Application No: 6/2021/1973/FULL
Location: Manor Cottage Vineyards Road Northaw Potters Bar EN6 4PQ
Proposal: Erection of replacement residential dwelling following the demolition of existing
Officer: Ms Emily Stainer

Recommendation: Refused

6/2021/1973/FULL

1 Front elevation with all permissions completed
1:100

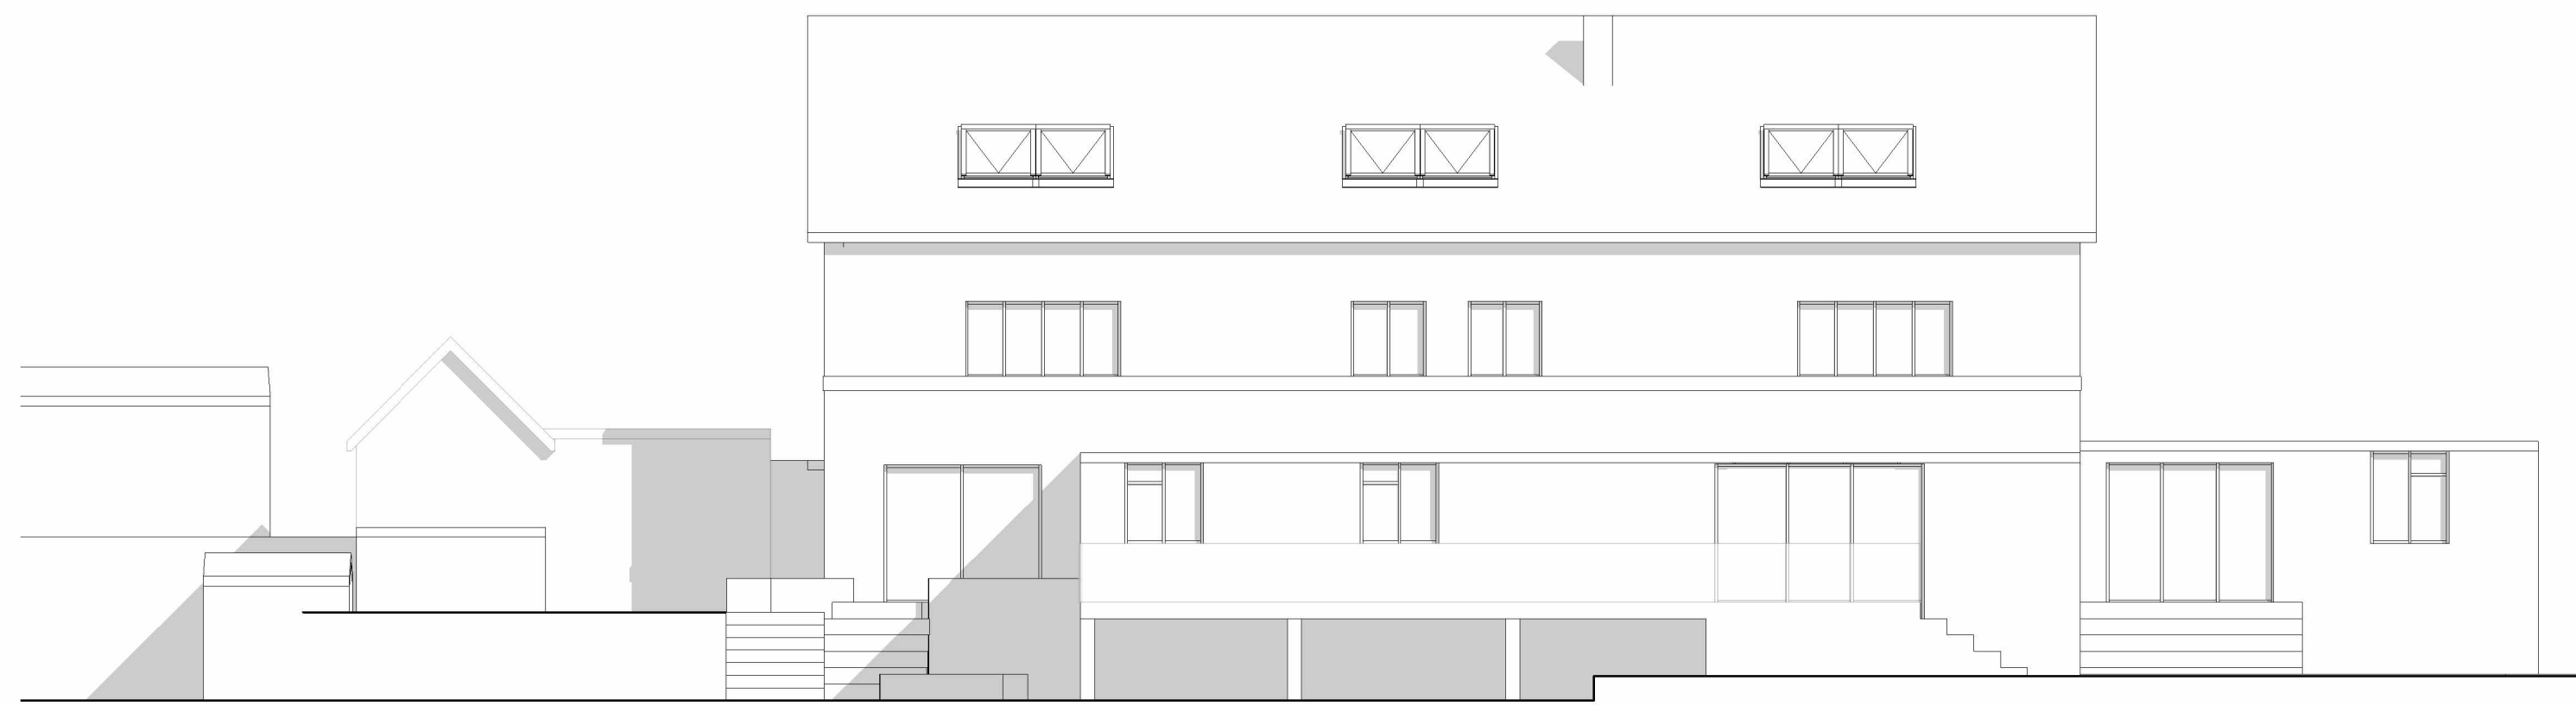
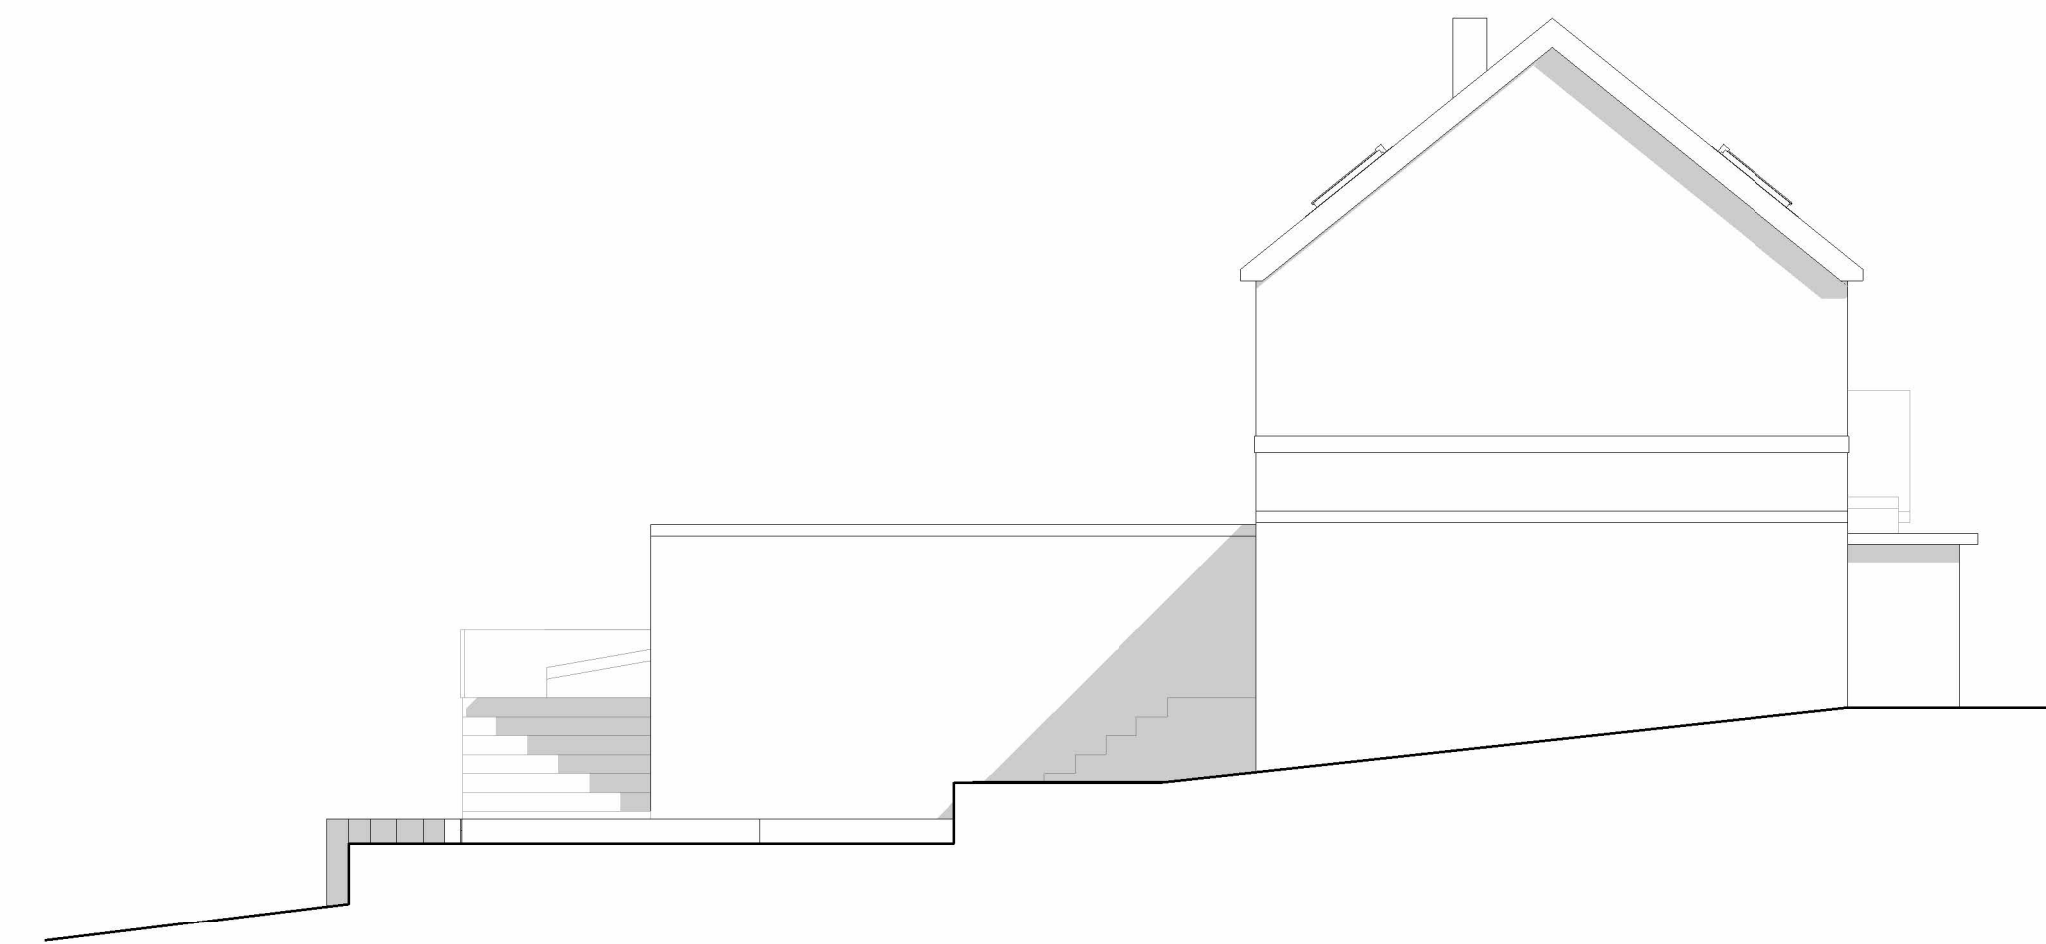
The height has also been referred to as part of the VSC argument, with particular reference to the prior approval application for an additional storey. The eaves height of the extant permission for the additional storey (6/2020/3347/PN27) is approximately 5.6m and approximately 9m to the ridge at the front of the property. The proposed dwelling would have roughly the same eaves height (at its highest level as the eaves height differs) and the main ridgeline would sit just below that of the approved dwelling with the additional storey due to the difference in land levels (as indicated on the proposed elevations). The main part of the approved dwelling with an additional storey (minus the outbuilding) has a total width of approximately 23m, with the part which extends above ground floor level measuring approximately 19m in width. The resultant dwelling which is proposed as part of this application would have a total width of approximately 29.2m. Although some elements are set down from the ridgeline of the highest part of the house, the full width of the dwelling would extend above ground floor level, increasing the bulk and massing of the property at first floor compared to the fallback position which comprises a reduced width at first floor. Similarly, the depth of the approved PD elevations would measure approximately 7.8m as shown on the submitted plan, whereas the resultant dwelling would measure approximately 13m in depth at first floor level.

Therefore, in summary, due to its notable increase in width, depth and bulk, particularly at two storey level and along with the contemporary design and further glazing compared to the approved two storey dwelling with single storey subordinate elements, it is considered the new dwelling would appear larger and more prominent in the landscape than either the existing dwelling or a separate scheme which benefits from prior approval.

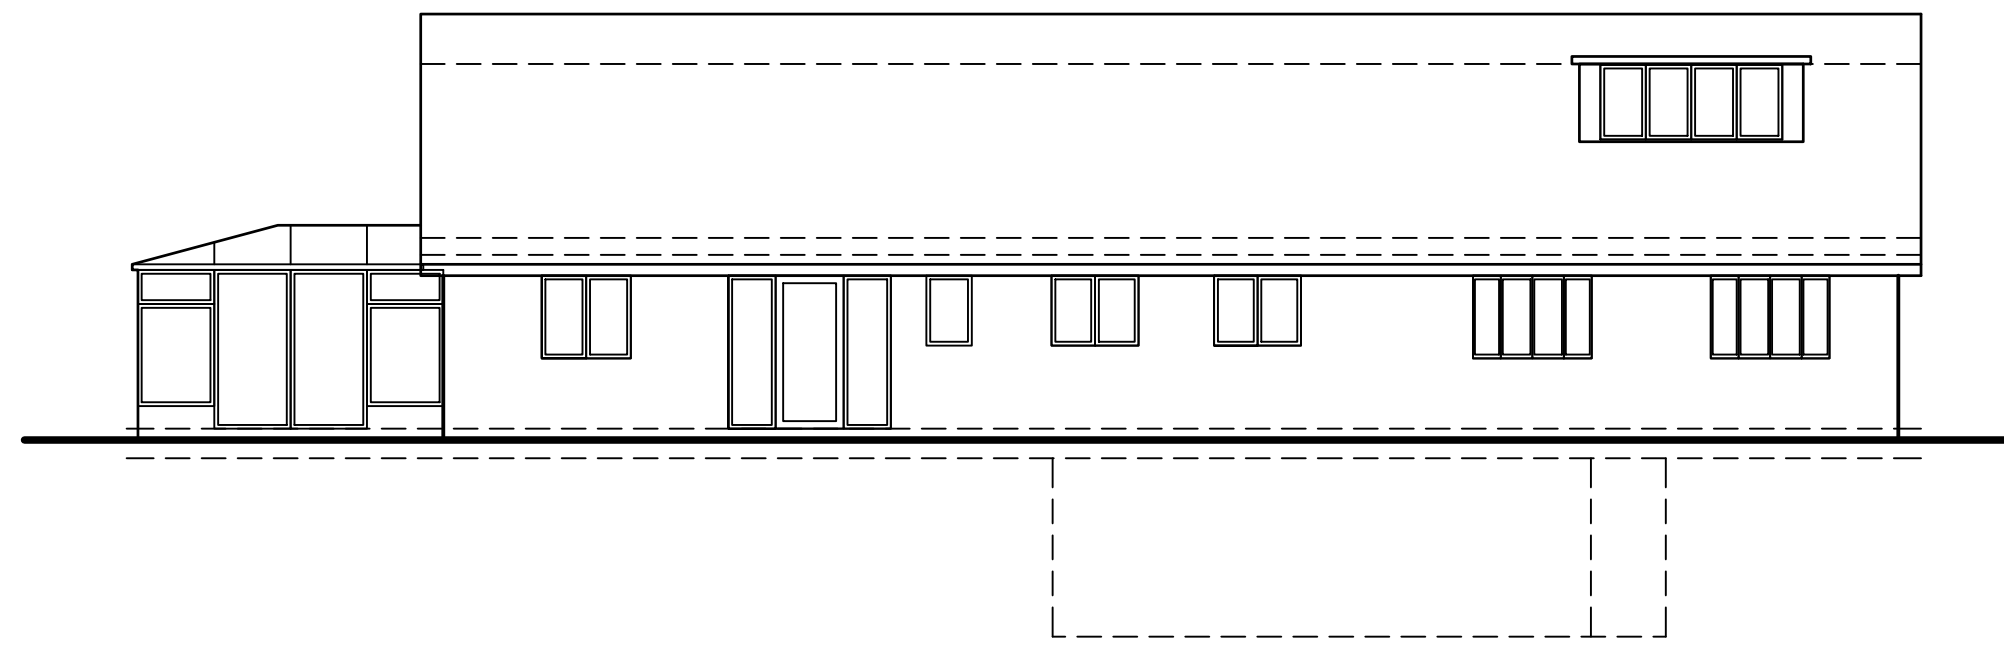
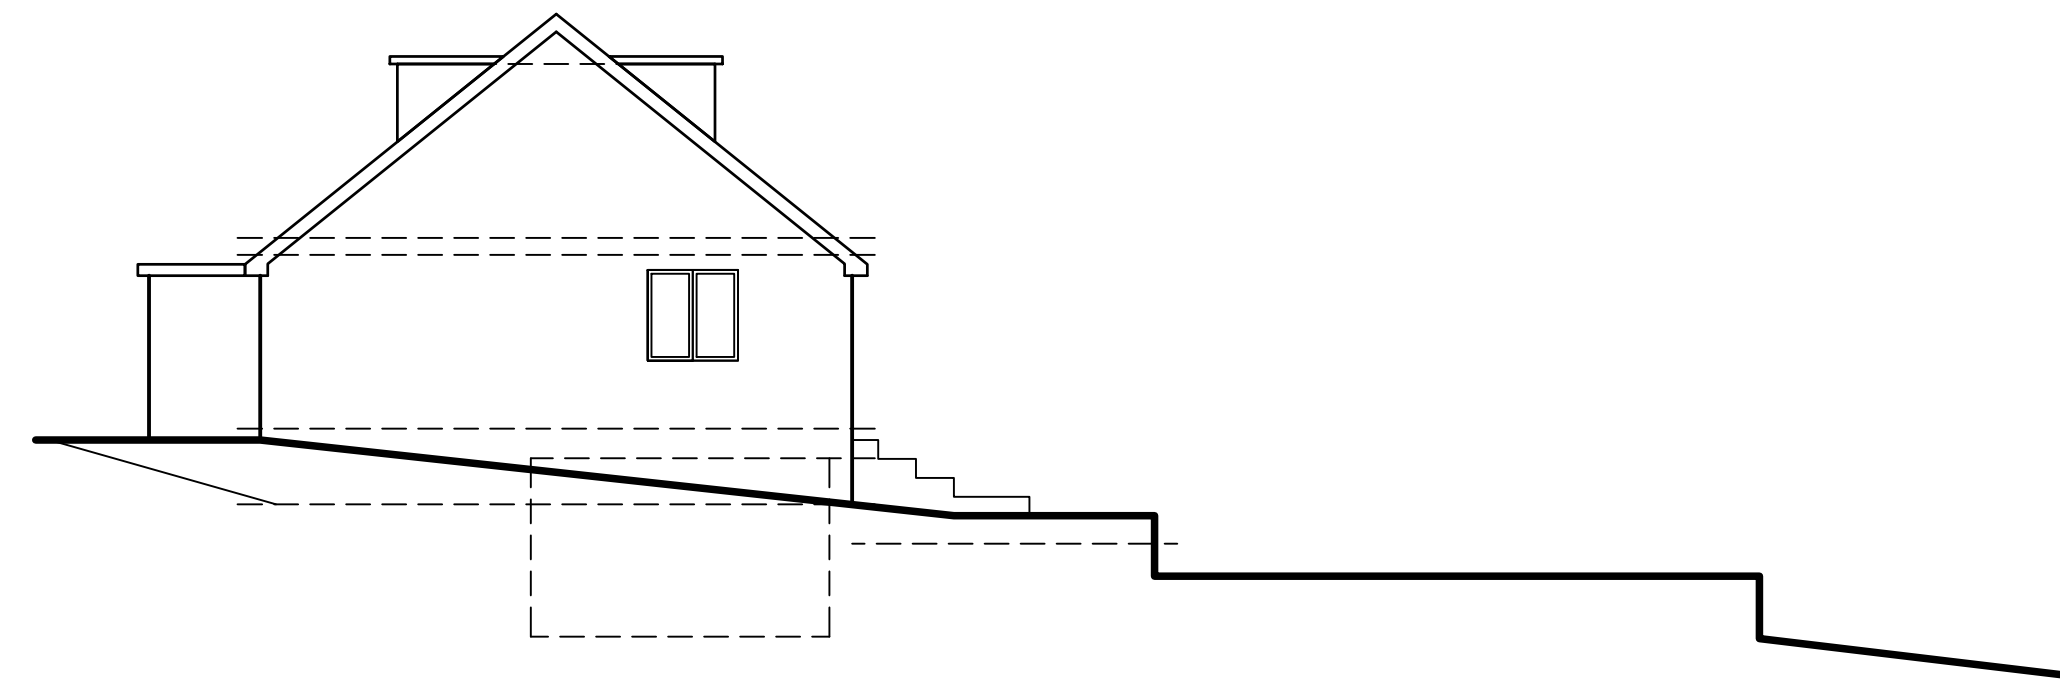
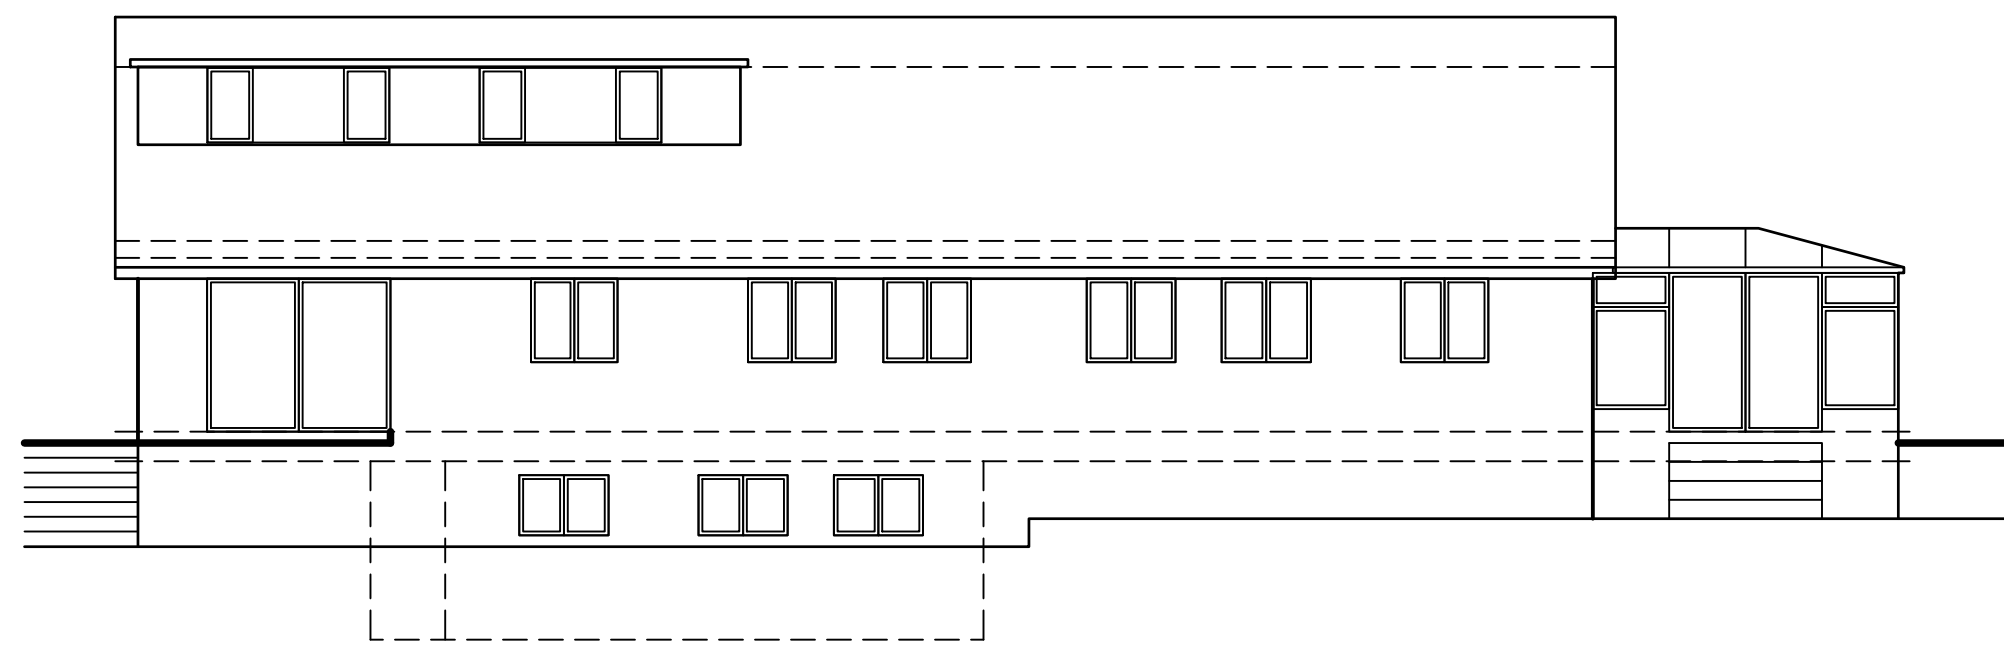
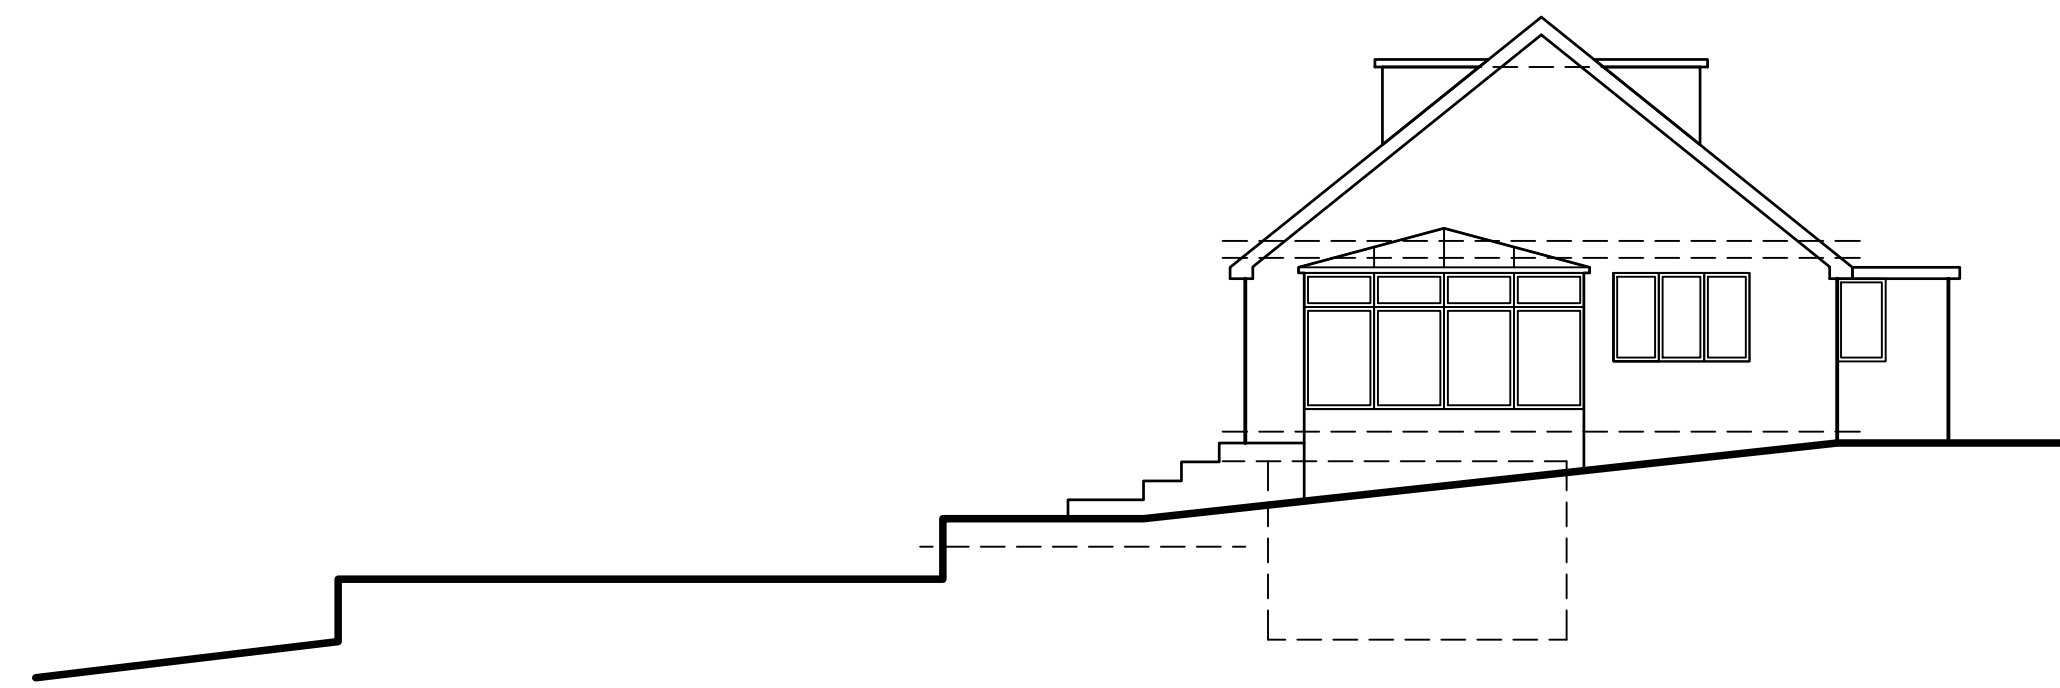
The main part of the existing dwelling is predominantly on the ground floor. The roof space currently accommodates a bedroom with an en-suite and a study room. The lower ground level of the property is a basement. The property itself is finished with a simple pitched roof and two gable ends, a rear

dormer with a flat roof, a conservatory and a flat roof addition at single storey at the front. There are also some small outbuildings scattered around the dwelling. The property has an eaves height of approximately 2.1m above ground floor level at the front and approximately 3.4m at the rear due to the change in levels. The ridge height at the front is approximately 5.5m above ground floor level and the front and approximately 6.85m at the rear.

The existing dwelling is finished with render, brickwork and a pantile pitched

roof, in addition to smaller ground floor elements and a flat roof dormer at the back. Given the difference in land levels and access driveway which leads to Nyn Manor, the property is relatively visible from public vantage points, including from the main road (Vineyards Road). Whilst there is a hedgerow which extends most of the length of the eastern boundary of the site, the property (its rear elevation in particular) are still visible from public vantage points on the road. The direct neighbouring buildings to the site differ in character and design as they form a row of 4 terrace style cottages which have their frontages facing Vineyards Road. Comparatively, Manor Cottage has its principal elevation facing to the north, towards the access road to Nyn Manor Farm. On the opposite side of Vineyards Road are two large properties named Fairfields and Glenside. These properties are much larger in size than the cottages to the north of the application property, but they are set further back from Vineyards Road and partially screened by the dense vegetation along the boundary.
